National Grid Masterplans

Response of Roydon Parish Council, Norfolk, to National Grid Document: 8.4.12.2: Response to ISH2 Action Point 27 - Masterplans. Planning Inspectorate Reference: EN020027

Title:
Action Point 27: Waveney Valley (including Snow Street, Roydon Fen and Wortham Ling) - Draft Constraints Plan

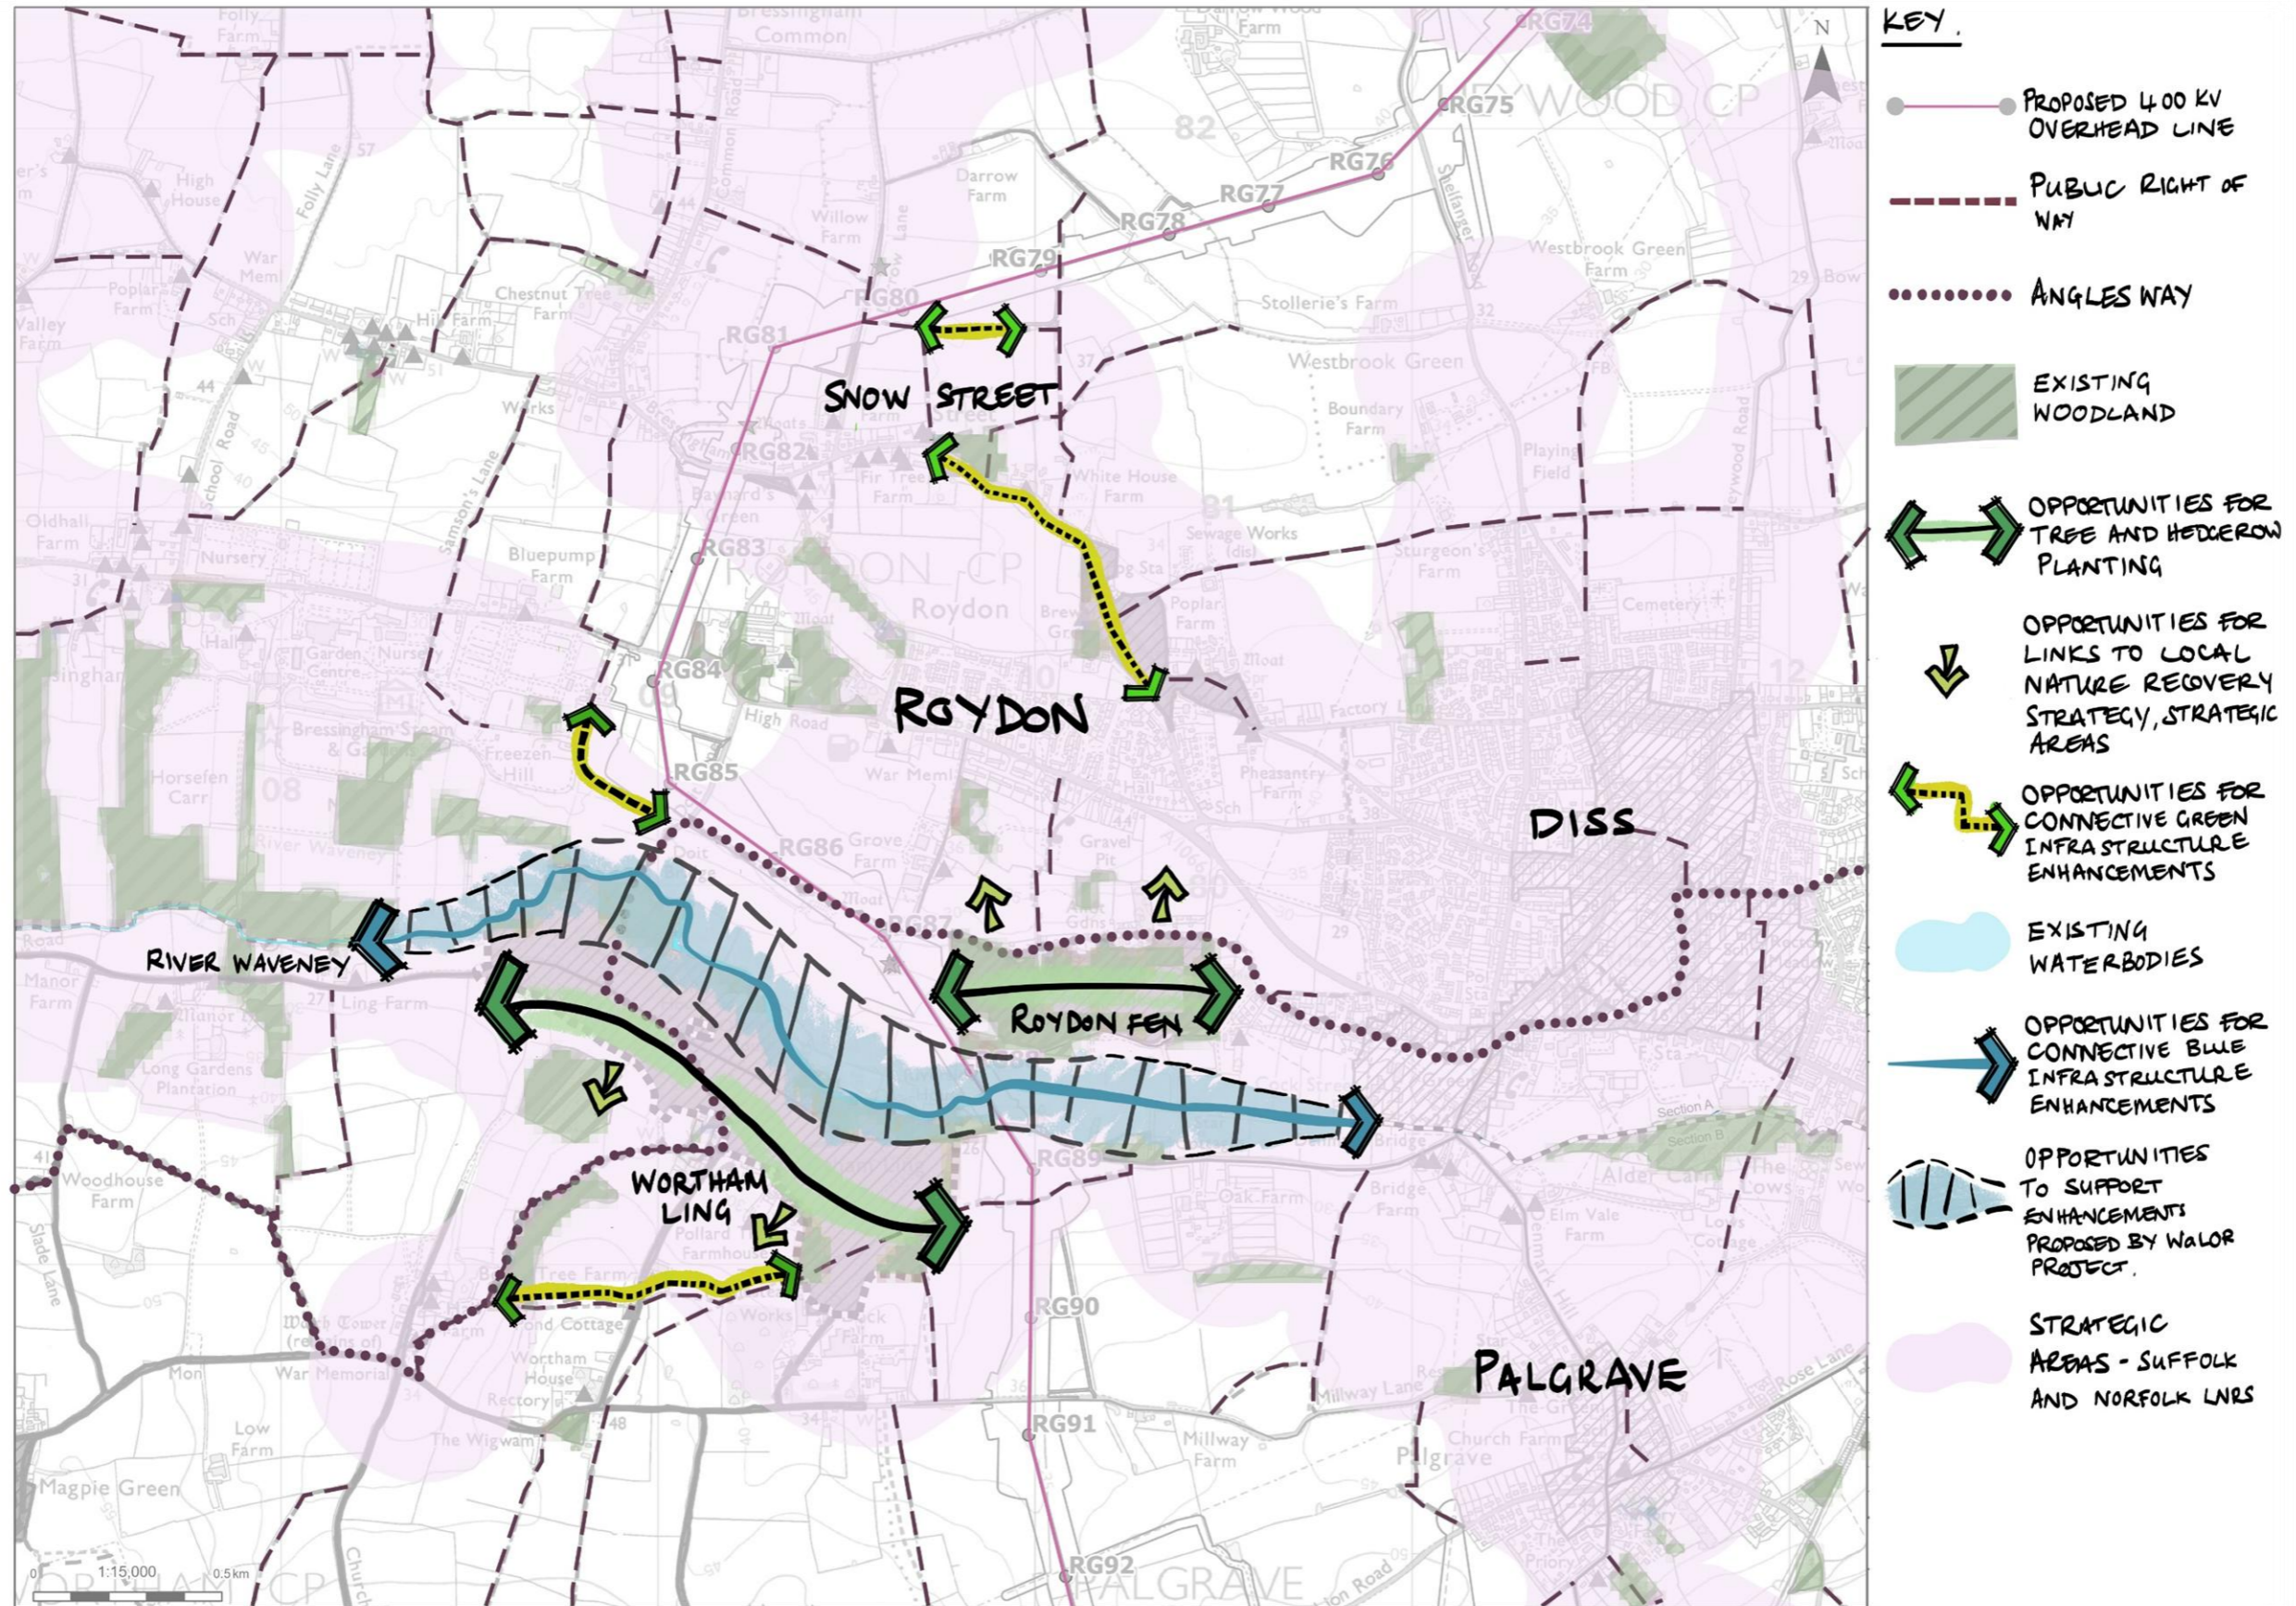
Roydon Fen. National Grid proposes the planting of trees and hedgerows at Roydon Fen. But this is a rare wetland nature reserve, managed by Suffolk Wildlife Trust, where it's important to control the spread of woodland to preserve the fen's characteristics. What National Grid is proposing would risk damaging the habitat.

Wortham Ling. Similarly, National Grid proposes tree and hedgerow planting at the Ling - a Site of Special Scientific Interest composed of acid grassland and dry heath. The Grid's proposal again completely fails to grasp the nature of the habitat they're referring to. Tree planting would fundamentally alter and damage this rare SSSI habitat.

Snow Street. The Grid proposes green infrastructure improvements but the western half of the highlighted section is already heavily wooded and / or with hedgerows and we question what additional work could be undertaken. The eastern end is Brewers Green, a County Wildlife Site, which is already managed to protect and enhance specific habitats such as ponds and open grassland. There is no indication of what green infrastructure the Grid is thinking about, but activities such as a significant programme of tree planting would again be considered inappropriate as it could threaten the future of these specific habitats.

Action Point 27: Waveney Valley – Draft Opportunities Plan

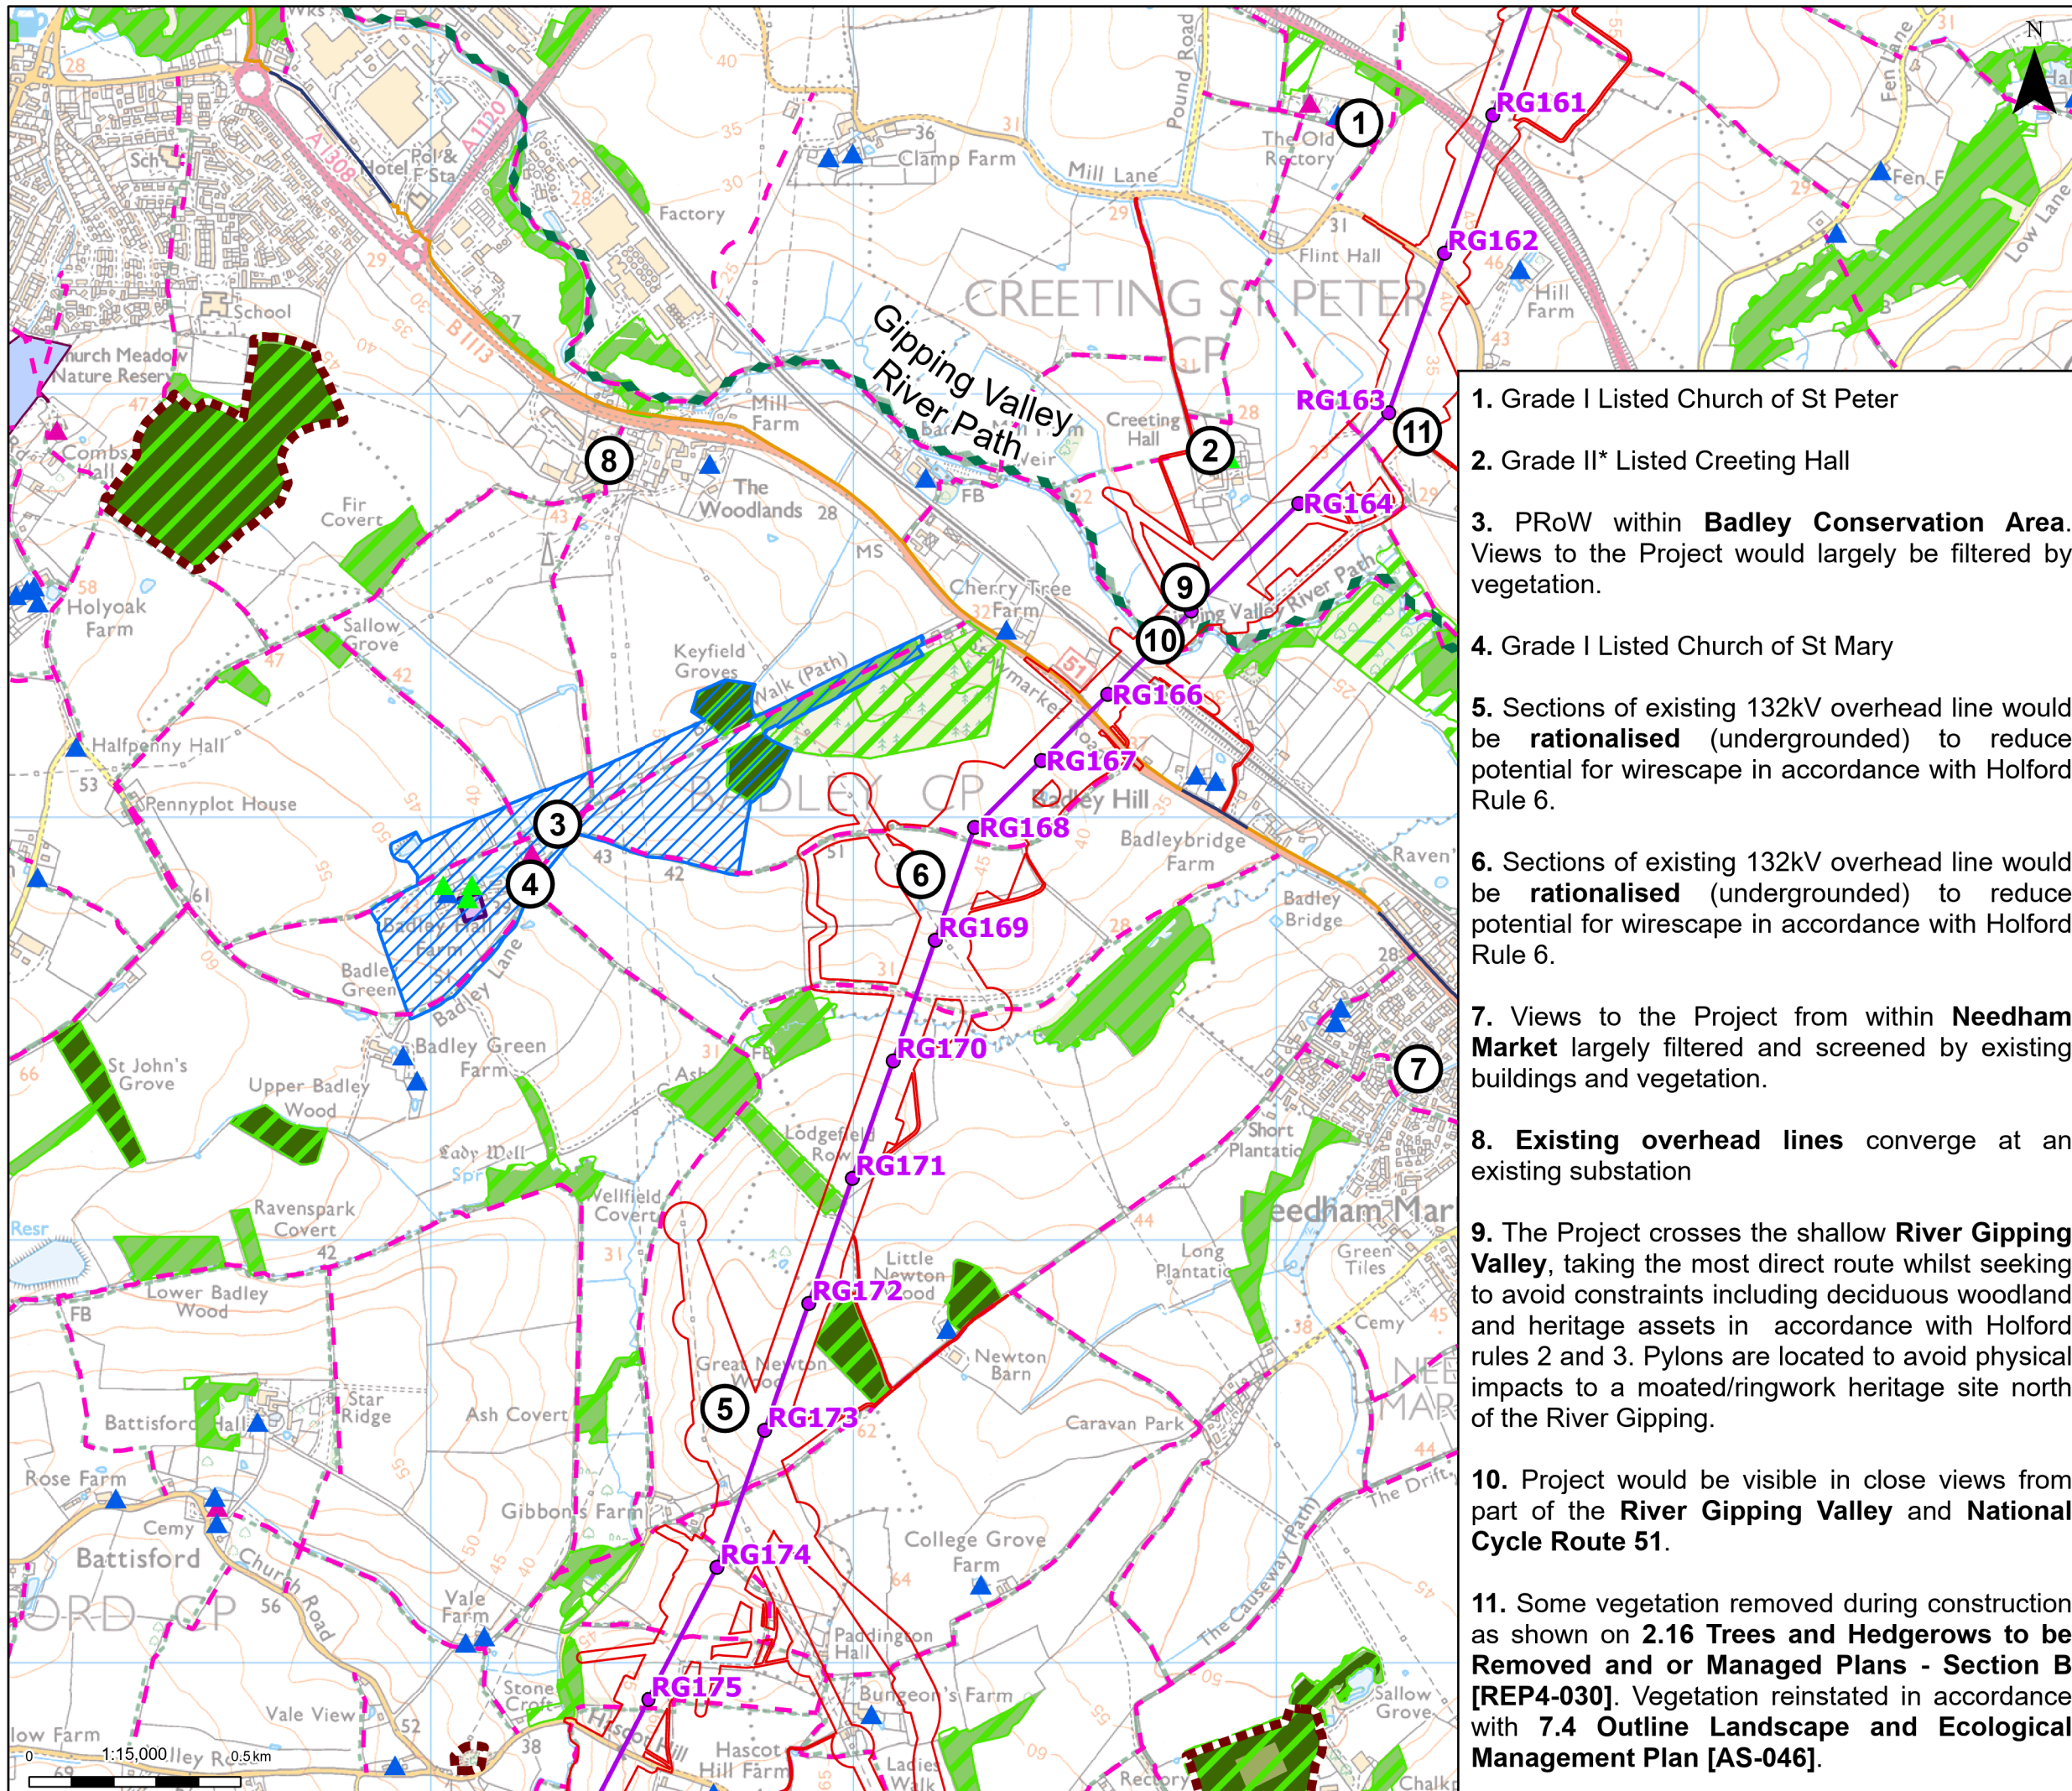
The masterplan proposes little relevant mitigation in relation to the 50m pylons to the north of Snow Street, which impact a key view listed in the Diss and District Neighbourhood Plan as well as several popular footpaths. Neither is there any mitigation in relation to pylons impacting the Angles Way footpath in the valley, which they cross, or views of the Grade 1 listed St Remigius Church. The Grid's suggestion that existing greenery protects views of the church is a falsehood.
